# Rezoning Transportation Analysis

Petition Number: #2022-087

General Location Identifier: 04715204, 04715205, 04715206, 04715208

Date	Description
11-28-22	First Review (TM)
12-22-22	Second Review (DR)
1-23-23	Third Review (DR)
4-27-23	Fourth Review (TM)

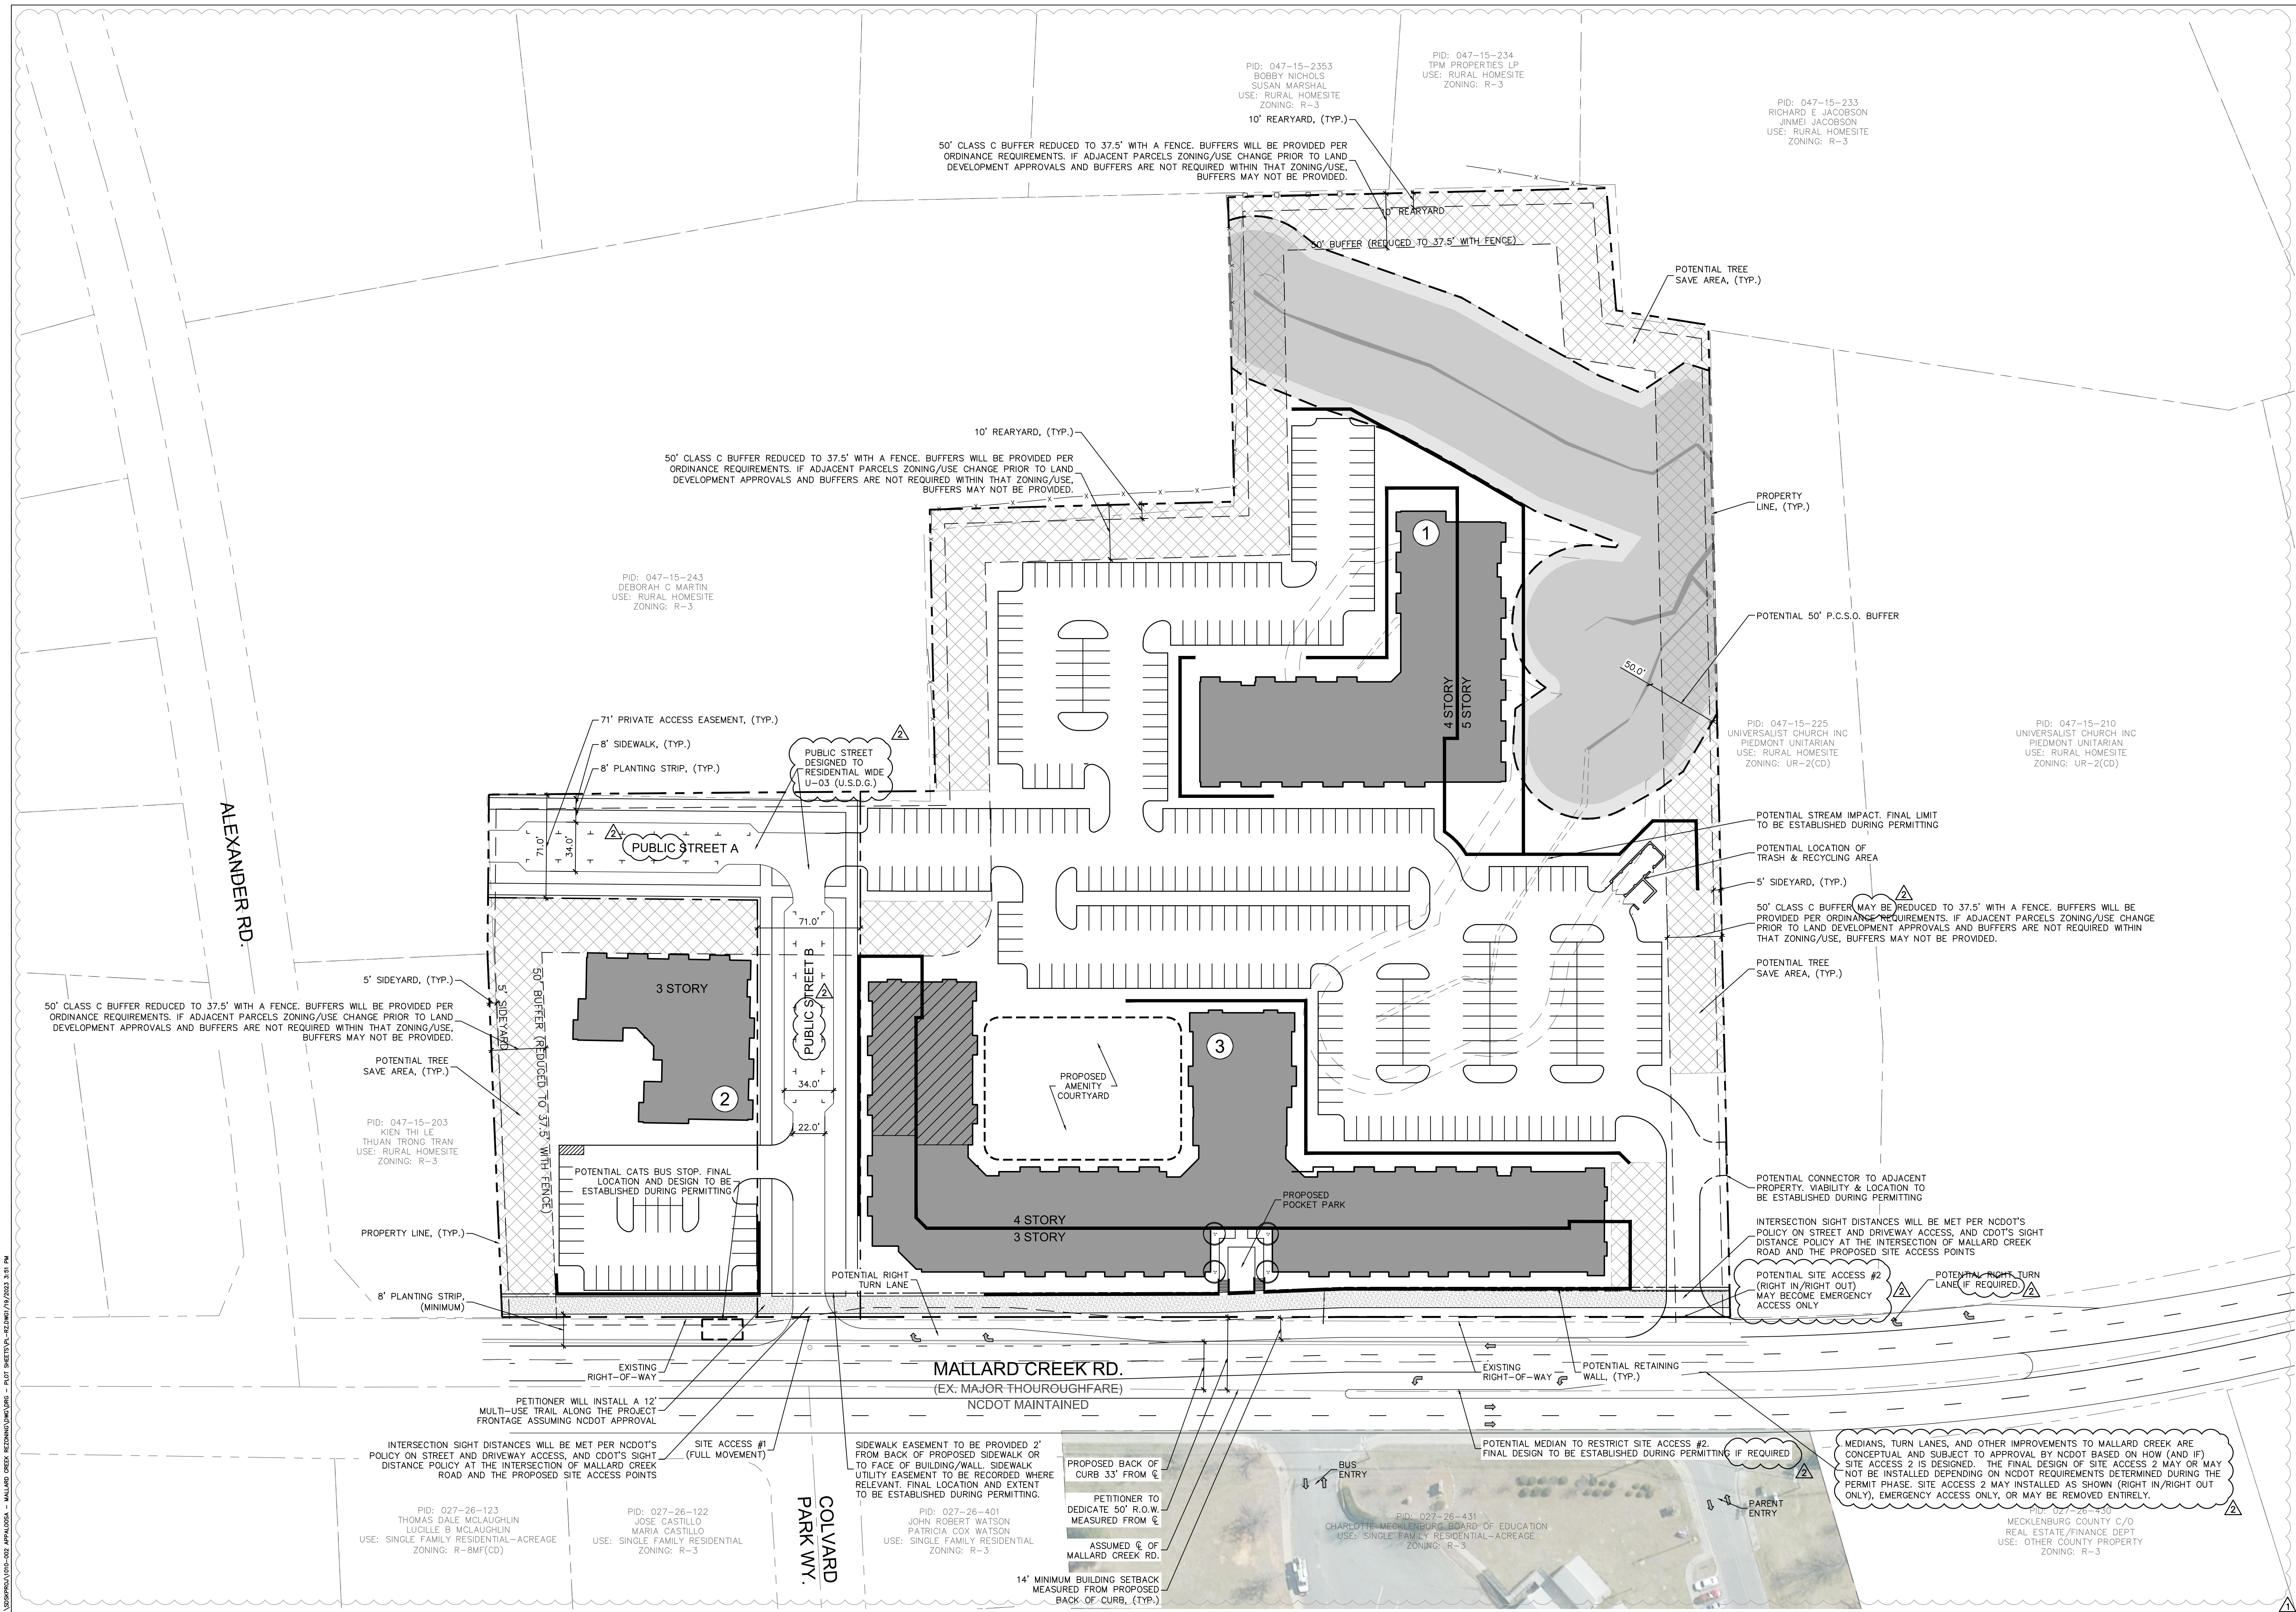
Label and dimension the curb and gutter from the centerline for each road on the site plan.
2. ~~**Traffic Study:**~~

A Traffic Impact Study (TIS) is not necessary for the complete review of this petition due to the site generating less than 2,500 daily trips. If during the permitting process the site generates more than 2,500 daily trips, then a traffic study will be required.
3. ~~Revise site plan and conditional note(s) to commit to dedicate 50 feet of right of way from the road. The site plan shall label and dimension the right of way from the road centerline.~~
4. ~~Revise site plan and conditional note(s) to commit to constructing internal public roadways designed to the standard of CLDSM U-03 and extend the north to south roadway to Alexander Road. The site plan shall label and dimension the ROW, curb and gutter, and the sidewalk from the roadway centerline.~~

The petition is located on the east side of Mallard Creek Road, a State-maintained major throughfare south of Alexander Road, a City-maintained local road. A Traffic Impact Study (TIS) is not needed for this site. Petitioner committed to constructing Private Street A and Private Street B as public roads, installing a 12-foot multi-use path and 8-foot planting strip along Mallard Creek Road, and coordinating access changes during permitting. CDOT has no outstanding issues.

~~Clarifying comment from 12/22/2022: Private Street A and Private Street B will both need to be public streets per coordination with subdivision. Remove all references to private access easements for Private Streets A and B.~~

~~5. New comment from 12/22/2022: Modify median to ensure full movement for development adjacent can be retained from parcels 04715225 and 04715210. What is being proposed will create a change of access for the development adjacent to property.~~

- 6. ~~The proposed dwelling units exceeds 12 per acre. Per Chapter 20 Subdivision ordinance, site plan and conditional note(s) revisions are needed to commit to construct an 8-foot planting strip, and 8-foot sidewalk along all internal public roads. The wider sidewalk also meets the Charlotte WALKS Policy.~~
- 7. ~~Revise site plan and conditional note(s) to commit to construct an 8-foot planting strip, and 12-foot sidewalk along the sites frontage per Chapter 19. The site plan shall label and dimension both items from the back of curb and gutter and road centerline.~~
- 8. ~~Revise site plan and conditional note(s) to commit to the southern site access as right in or right in/right out only. The northern site access at Colvard Park Way may be constructed as full movement. Site plan shall callout access restrictions of both site entrances.~~

~~Modify conditional note to specify that final design and location of southern driveway access will require additional coordination during permitting and may require infrastructure changes such as re-striping and/or concrete medians.~~

- 9. ~~Revise site plan by showing existing infrastructure along Mallard Creek Road including the existing driveways on the western side of Mallard Creek Road.~~

~~14. **New comment from 12/22/2022:** Remove word "potential" on callout for right turn lanes at site accesses. This is an NCDOT requirement. Add conditional note regarding right turn lanes at each site access. Label and dimension right turn lanes.~~

~~15. **New comment from 12/22/2022:** Remove "assuming NCDOT approval" on callout for 12 foot multi-use trail.~~
